Weir Phillips Heritage

Re: Amended Concept Proposal for Cockle Bay Wharf (SSD 7684), 17-27 Wheat Road, Sydney – Heritage Response

This letter responds to The Council of the City of Sydney's concerns relating to the heritage impact of the amended concept proposal for Cockle Bay Wharf (SSD 7684). The heritage objection is outlined below:

PROPOSED

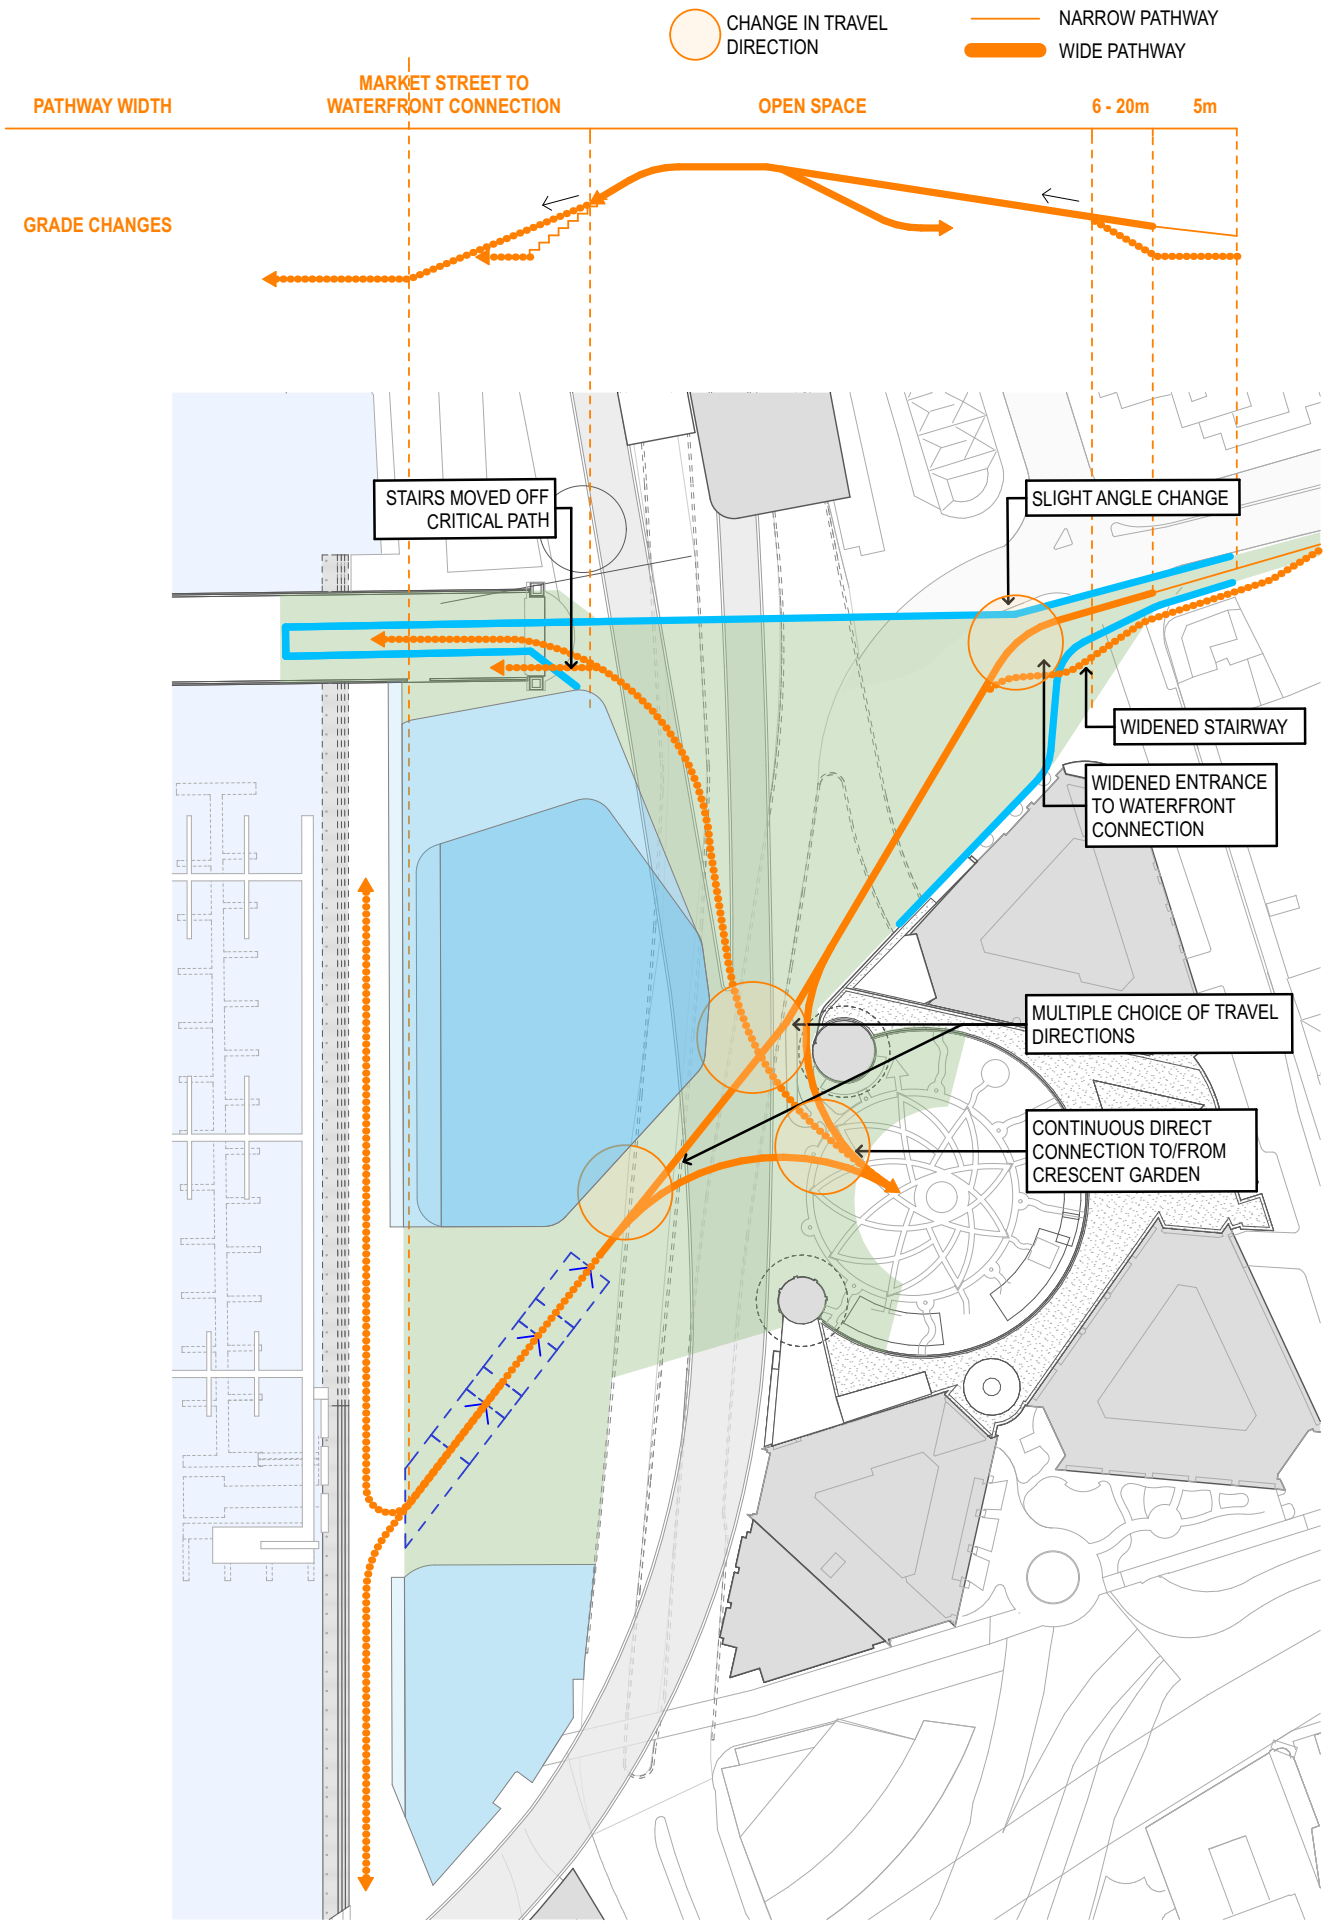
The proposed connection from the amended terraced public landscape to Pyrmont Bridge had been amended. It now connects to the east bridge abutment added in the 1990s and is potentially acceptable. However, the submission mainly uses photo montages and sketch plans to describe this work. Some of these images appear to indicate that the new bridge will cut much closer to the historic Corn Exchange building than existing bridges. This would not be acceptable. In particular, the detailing of the north edge/road portal of the proposed land bridge requires careful detailing as it will be seen as a road portal along the axis of Market Street from the east. The alignment, design and detail of the Market Street land bridge link to Pyrmont Bridge must be resolved to enhance the setting of the Corn Exchange and ensure a high quality and resolved design of the north edge of the new bridge. The detailed design of the connection to of Pyrmont Bridge must be resolved with the input of heritage architects and articulated in the heritage impact statement.

The proposed interface with the pedestrian link and the Pyrmont Bridge will utilise the existing modern fabric connections to the bridge, see **Figure 2** below. The connection will utilise the existing pedestrian link on the far eastern point of the bridge and connect to the lower terrace via staircases and escalators. This option provides an axial connection with Market Street as well as a wider and improved egress for event mode and day to day operation.

This option also allows for the removal of the existing side pedestrian access to Pyrmont Bridge, this will have a positive heritage impact as the profile of the southern elevation will be visible in full. The alignment, design and detail of the Market Street land bridge link to Pyrmont Bridge will be resolved to enhance the setting of the Corn Exchange in the detailed design phase. The Design Architect will consult with Council's Heritage Officers during the design development phase.
